## DECISION DELEGATED TO HEAD OF PLANNING

**Application No:** H16-0276-25      **Applicant:** Mr C Bond  
**Proposal:** Replacement dwelling following permission for demolition of existing dwelling. Approved under H16-0423-18. Modification of Condition 2 to allow amendments to previously approved plans  
**Location:** 11 Tower Lane Spalding  
**Terminal Date:** 13th May 2025

This is a Section 73 application, seeking to modify condition 2 of planning approval, H16-0423-18. Condition 2 relates to the 'Approved Plans' and this Section 73 seeks to alter the approved plans through providing additional bedrooms and a side extension.

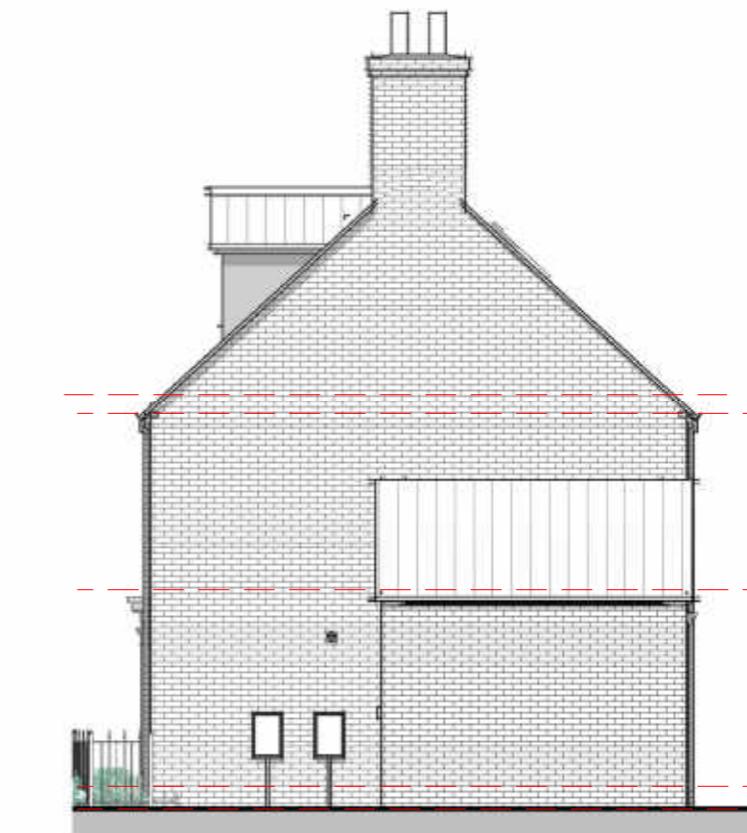
It is proposed that the attic would be converted to allow for two additional bedrooms, taking the dwelling's total to six. To facilitate these changes, five rear windows, in the form of roof lights, and three dormer windows to the front are proposed.

A mono-pitched side extension, measuring 3.15m (width) by 3.75m (depth) is proposed. It would have a height to the eaves of 2.75m, rising to 4.3m at its apex. Two front facing windows and a rear door are proposed. All materials would match the host. To facilitate the change, a previously proposed boundary wall would be removed from the plans.

The proposed inclusion of the dormer windows would broadly be consistent with the design philosophy of the development. The dormers would be well integrated into the host and of a fairly traditional style. The roof lights would only be visible from the rear of the property, thereby reducing their impact upon the character of the development. In any event, the roof lights are well integrated into the host dwelling, particularly given the somewhat more modern design approach taken to the building's rear, and would have minimal impact upon the overall appearance of the development.

The proposed extension would result in the dwelling occupying a larger proportion of the plot. To a certain extent, this would result in the development appearing more dominant and somewhat more constrained in its plot; however, it is not considered that this would be to such an extent as to be harmful to the character of the area or significantly detract from the design of the dwelling. While the change in window design does lessen the integration of the extension to a certain extent, when considered as a whole, it is considered that the extension is well enough integrated into the host as to appear as a natural addition.

The dormer windows would not increase overlooking, as any views gained from them would be of the public realm. That being said, the rear windows would face towards neighbouring properties. As such, it is recommended that, in the event the proposal approved, a condition be added ensuring that the windows are non-opening and obscure glazed.

The proposed extension would not significantly increase overshadowing, due to its relatively low height.

As outlined in the report, it is recommended that an obscure glazing condition be added to ensure the proposal would not have an unacceptable amenity impact.
